RE: WINTERBOURNE WIND FARM SSD-10471

WINTERBOURNE WIND FARM SSD-10471

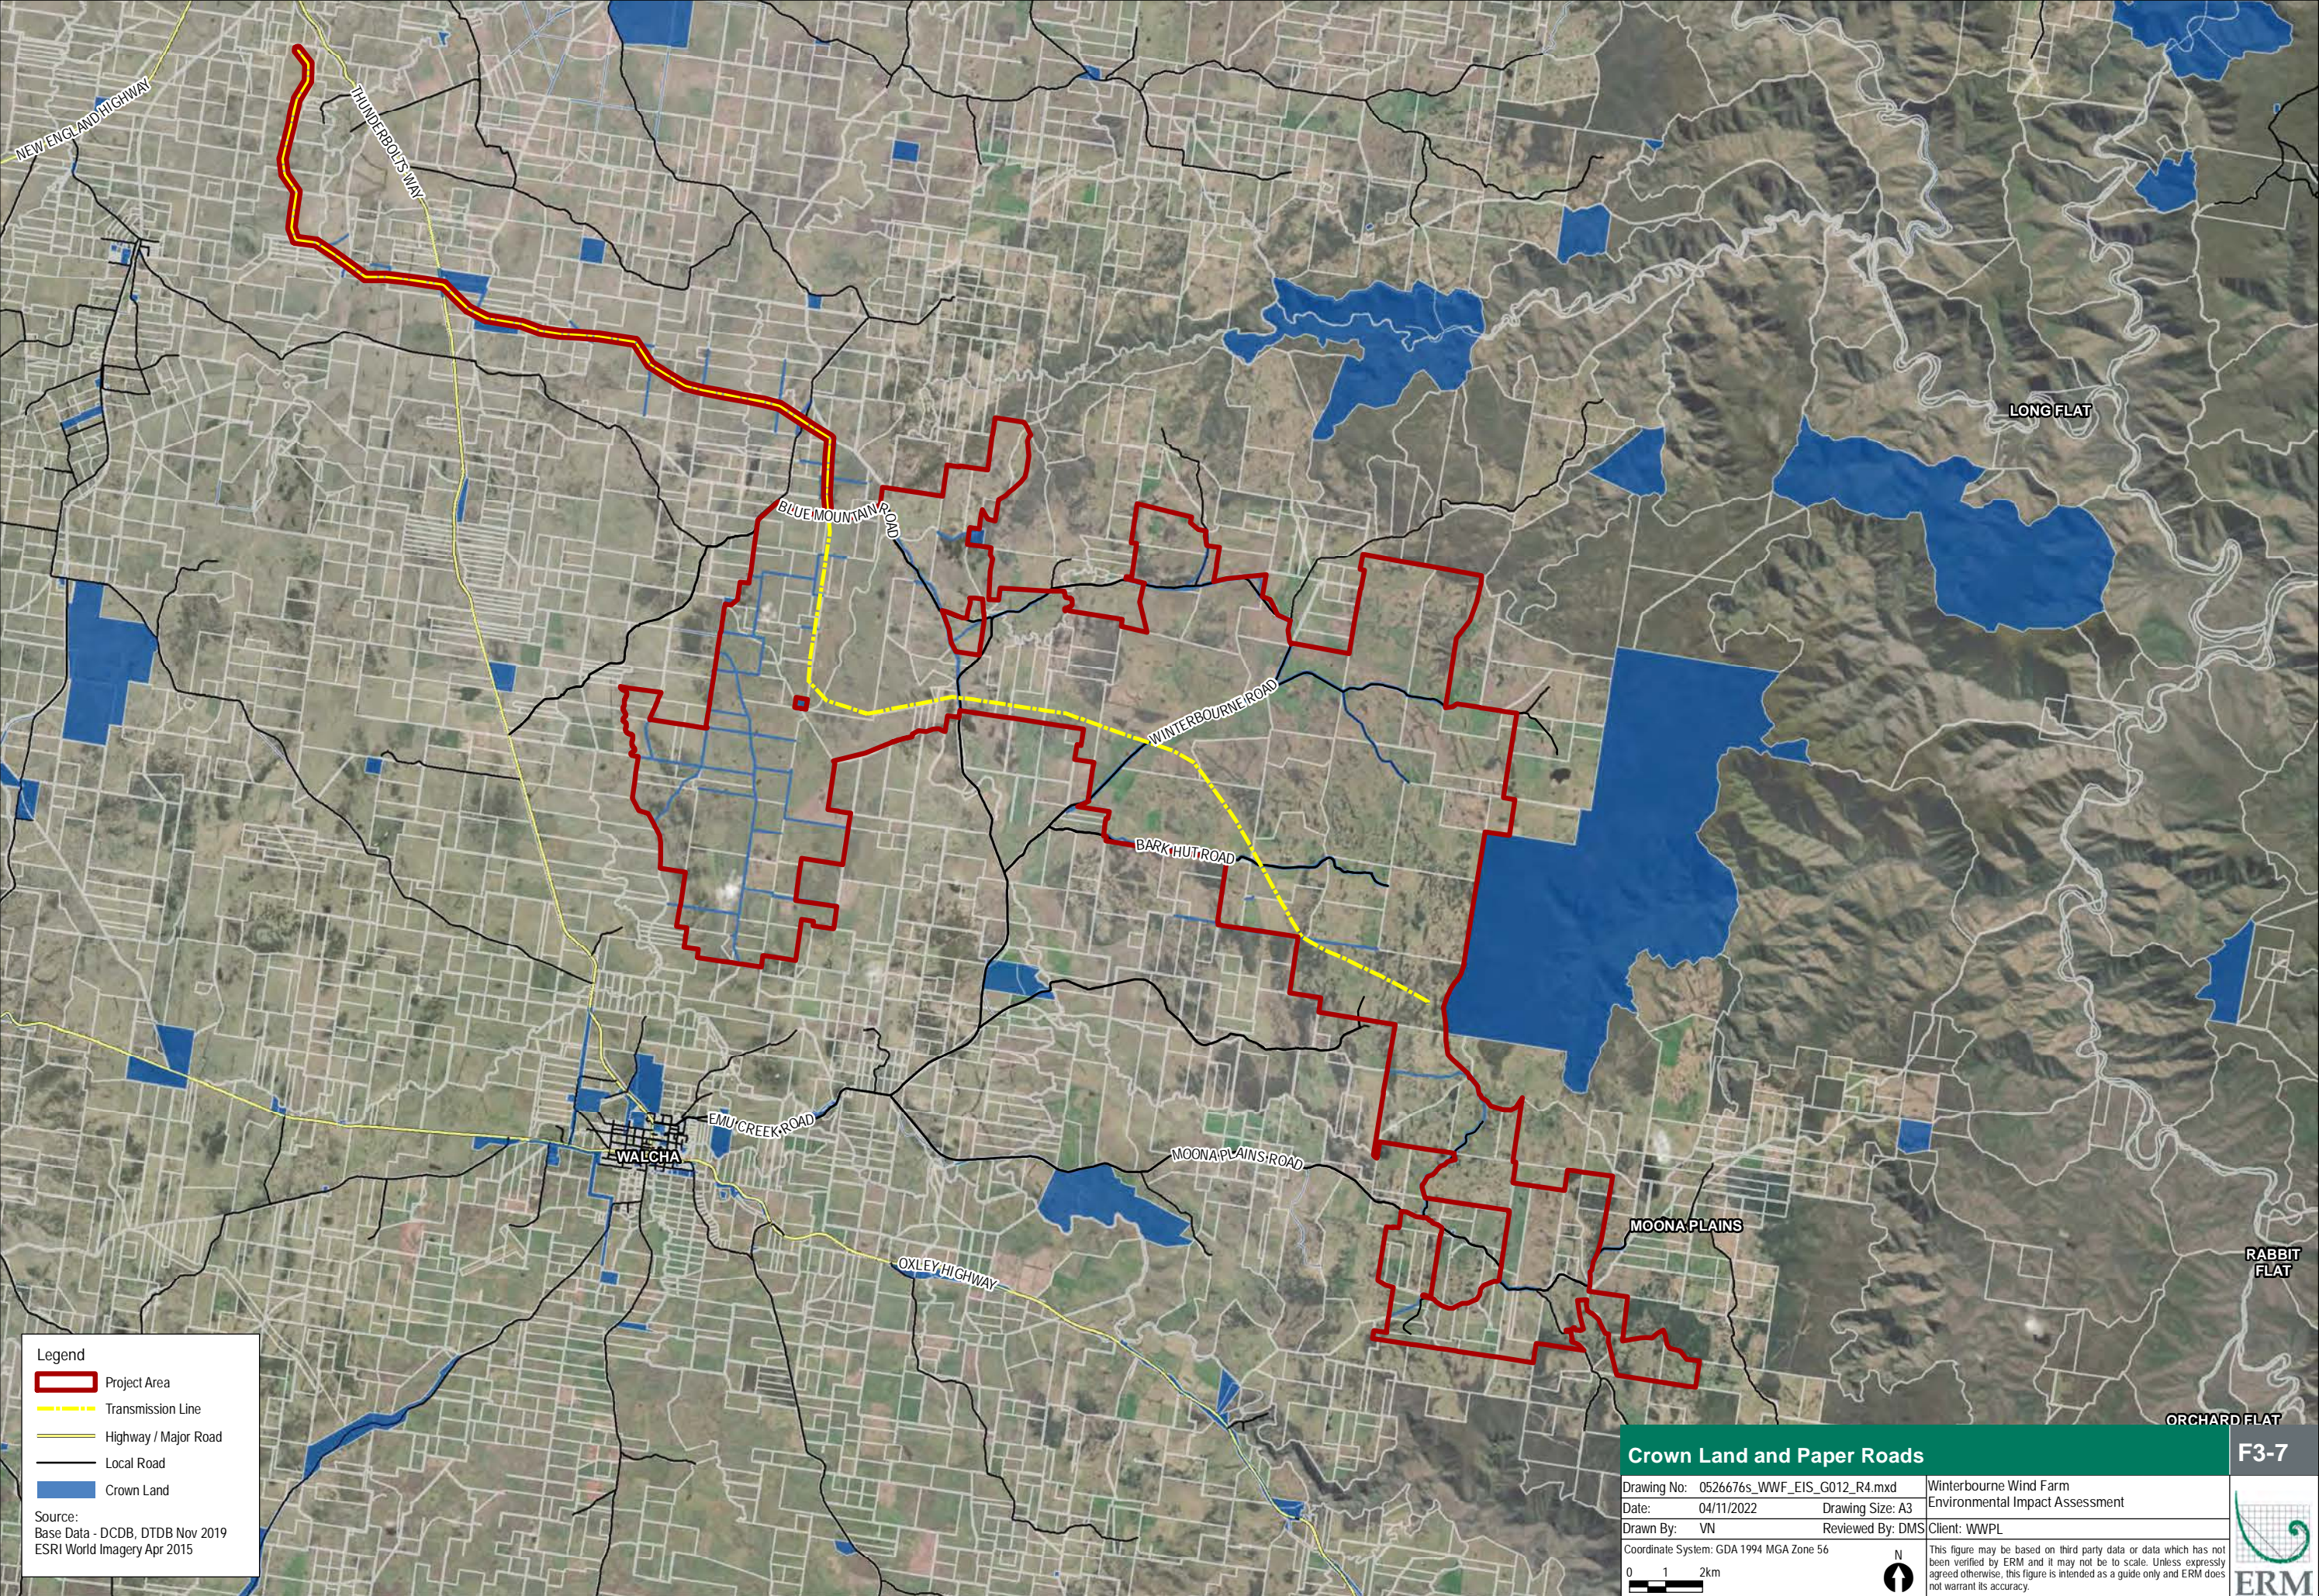
Firstly, significant time delays are expected as there are limited opportunities to pass wide loads, especially for livestock trucks, local roads do not accommodate safe passage in many locations. A drive to Moona Plains in a B-Double would demonstrate this point. Map F3-6 reveals the minimalist approach to mitigating this issue.
